# Consultee Comment for planning application 23/02399/REM

<b>Application Number</b>	<input type="text" value="23/02399/REM"/>
<b>Location</b>	<input type="text" value="Land North Of Bicester Avenue Garden Centre Oxford Road Bicester"/>
<b>Proposal</b>	<input type="text" value="Reserved Matters approval for 23/01080/OUT - Details of access, appearance, landscaping, layout and scale relating to the proposed development of Class E(g)(i) (formerly B1(a)) office/commercial building and Class E(g)(ii) (formerly B1(b)) Research and Development Units, plus associated car parking"/>
<b>Case Officer</b>	<input type="text" value="Tom Webster"/>
<b>Organisation</b>	<input type="text" value="Clerk to Chesterton PC"/>
<b>Name</b>	<input type="text" value="Jackie Williams"/>
<b>Address</b>	<input type="text" value="Chesterton Community Centre 2 Geminus Road Chesterton Bicester OX26 1BJ"/>
<b>Type of Comment</b>	<input type="text" value="Comment"/>
<b>Type</b>	<input type="text"/>

PROJECT Bicester Arc - YASA - Office	
TITLE East & North Elevations

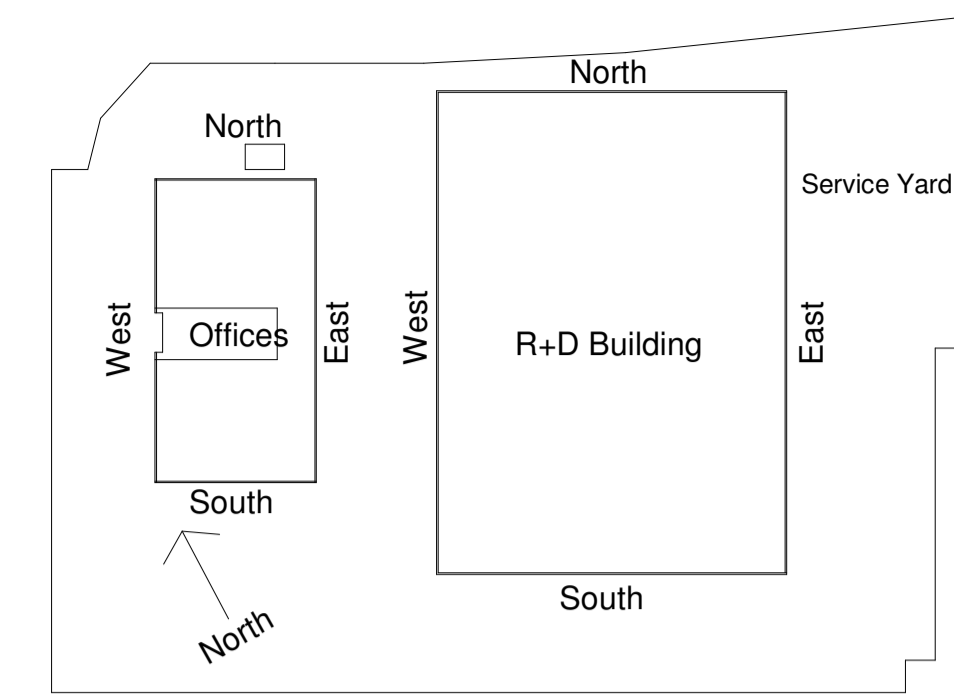
<b>Comments</b>	<input type="text" value="Chesterton Parish Council considers the proposed building to be too tall and out of keeping with the surrounding area. At 4 storeys in height, it is much higher than any other building around it, such as Tesco, David Lloyd and the Gateway offices.&lt;br/&gt;We consider that light pollution could present a problem from such a huge glass fronted building 4 storeys in height, and the proposed parking provision on site appears minimal for an office block of this size.."/>
<b>Received Date</b>	<input type="text" value="20/10/2023 12:19:39"/>
<b>Attachments</b>
